CITY OF ALBUQUERQUE

March 20, 2018

Re: Son Broadcasting
820 Candelaria RD NE
Traffic Circulation Layout
Architect's Stamp **02-05-18** (H15-D057A)

A1.1
TCL

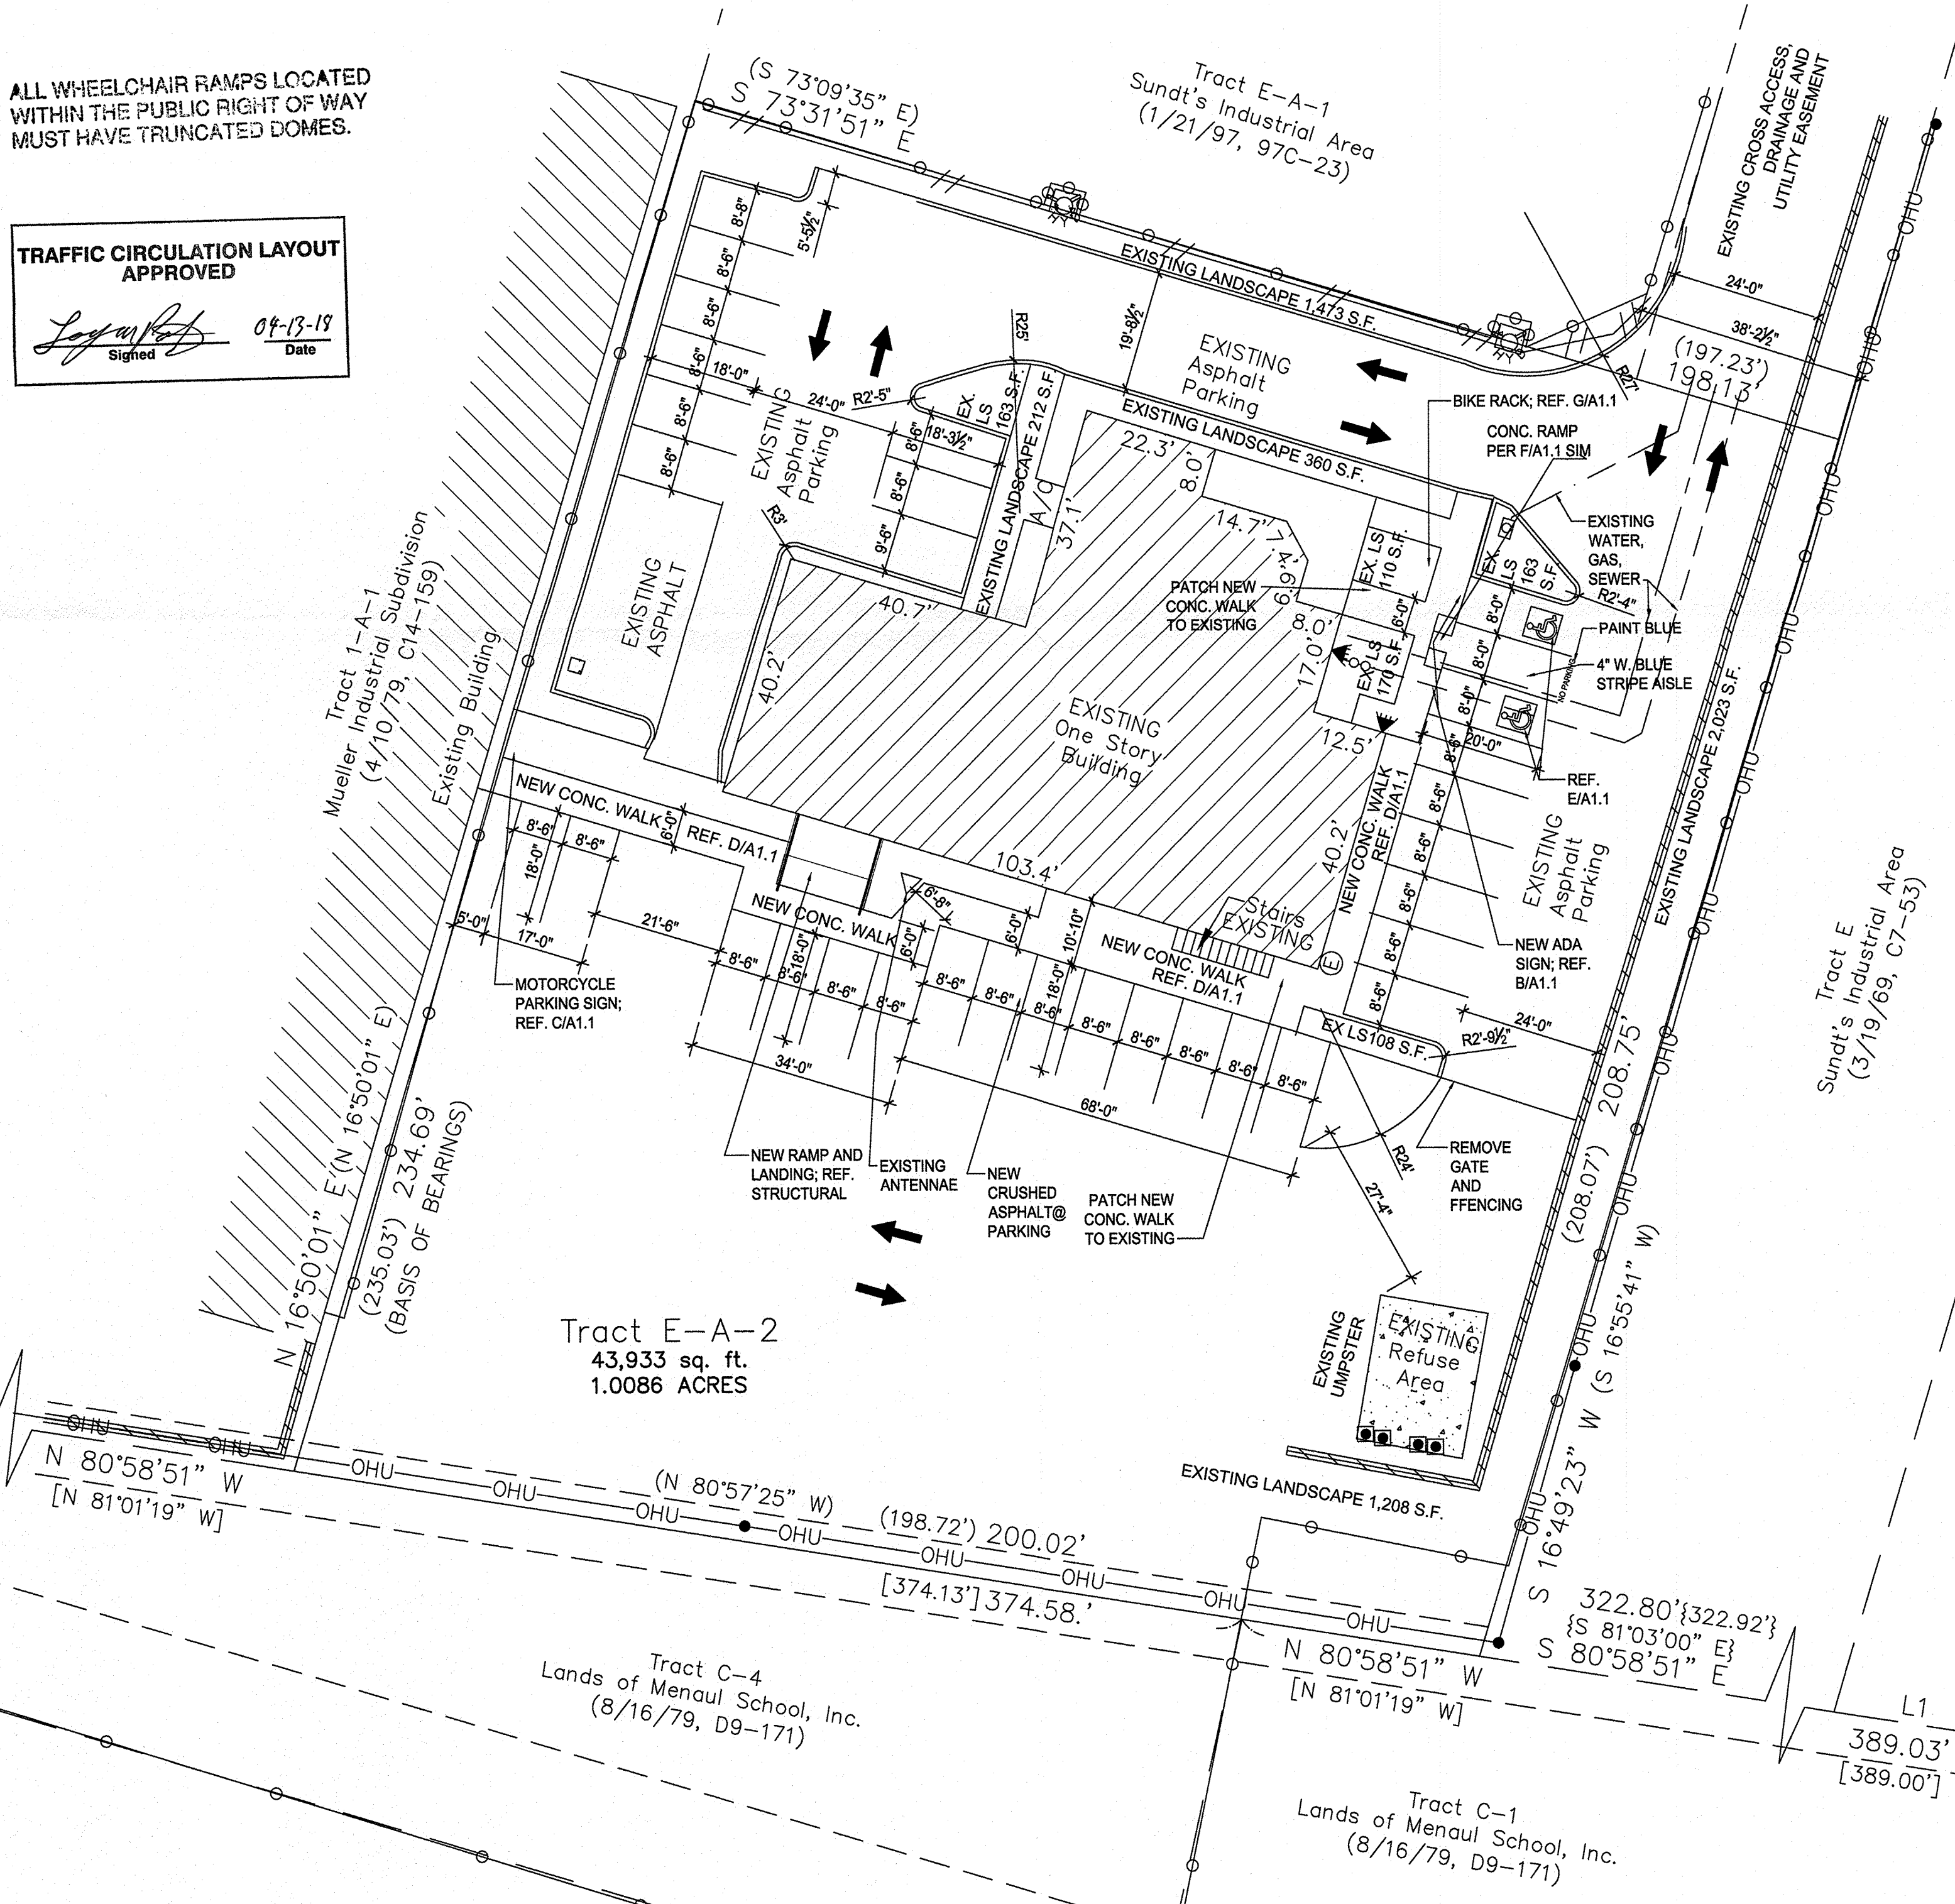
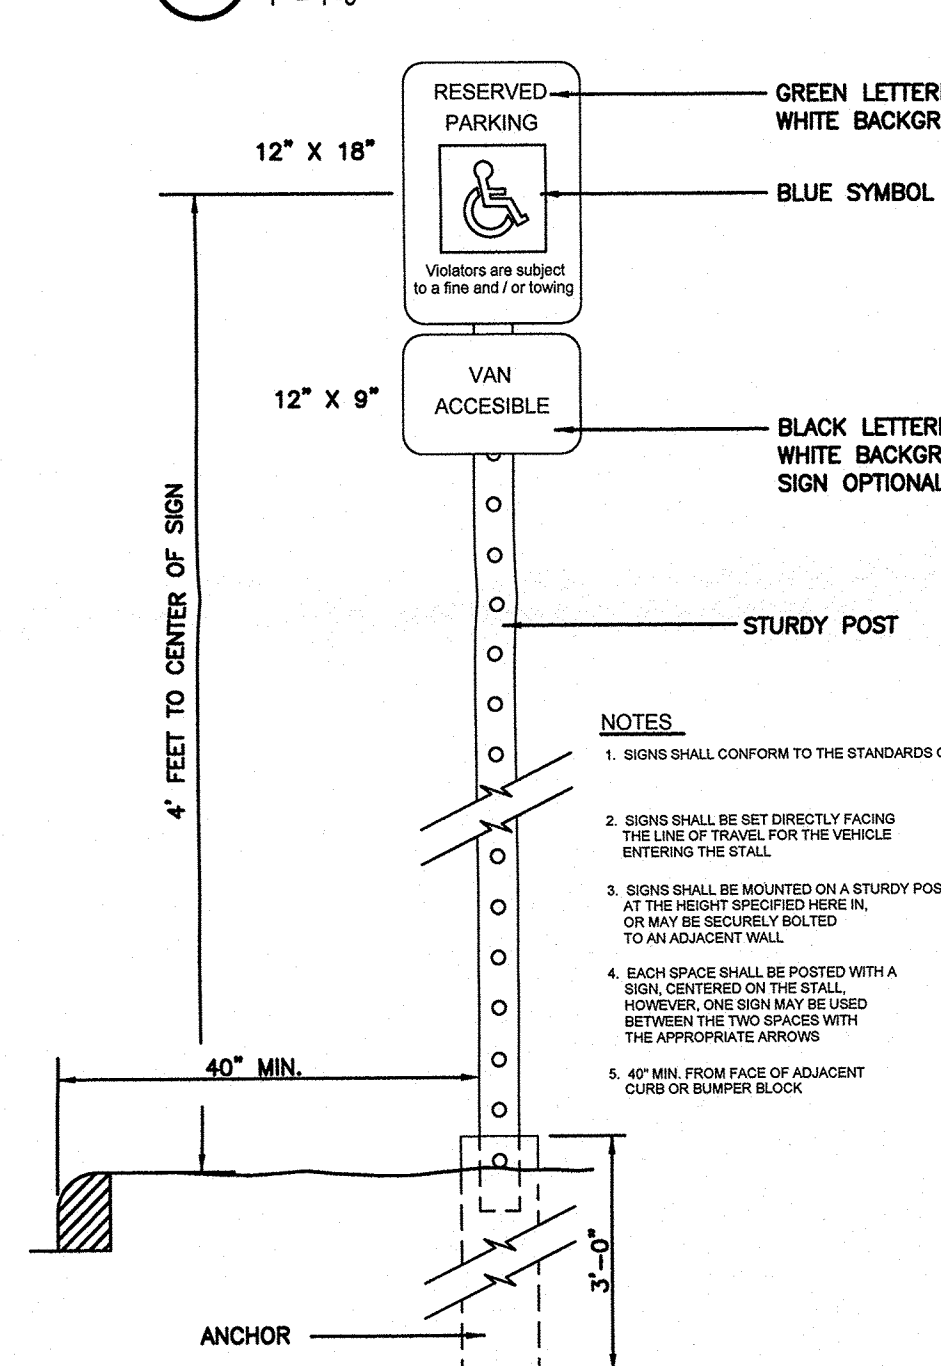
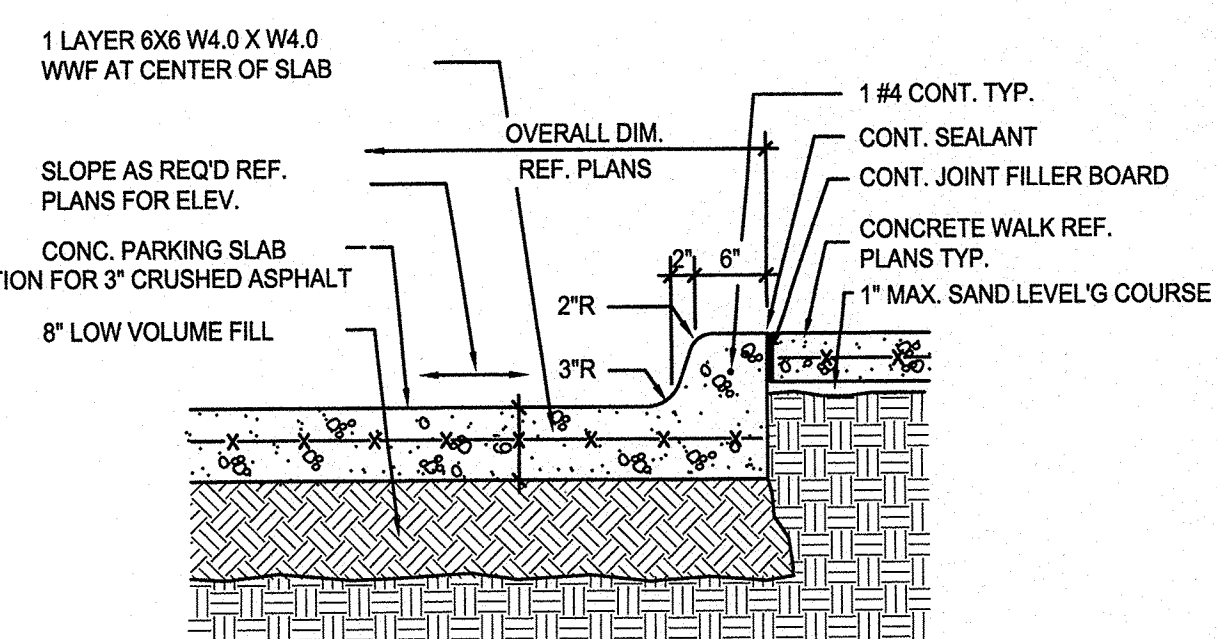
1. Identify all existing access easements with the neighbor property and rights of way width dimensions.
2. Please list the width and length for all existing and proposed parking spaces. Some dimensions are not shown.

3. The ADA access aisles shall have the words **"NO PARKING"** in capital letters, each of which shall be at least one foot high and at least two inches wide, placed at the rear of the parking space so as to be close to where an adjacent vehicle's rear tire would be placed. (66-1-4.1.B NMSA 1978)

4. Show all drive aisle widths and radii. Some dimensions are not shown.
5. Per DPM, a 6 ft. wide ADA accessible pedestrian pathway is required from the HC parking stall access aisles to the building entrances. Please clearly show this pathway and provide details.

6. It is not apparent what type of pavement surface is being proposed. A hard driving surface will be required as part of this proposed project for parking area and drive aisles. Please provide a detail or construction information for the new gravel parking area.
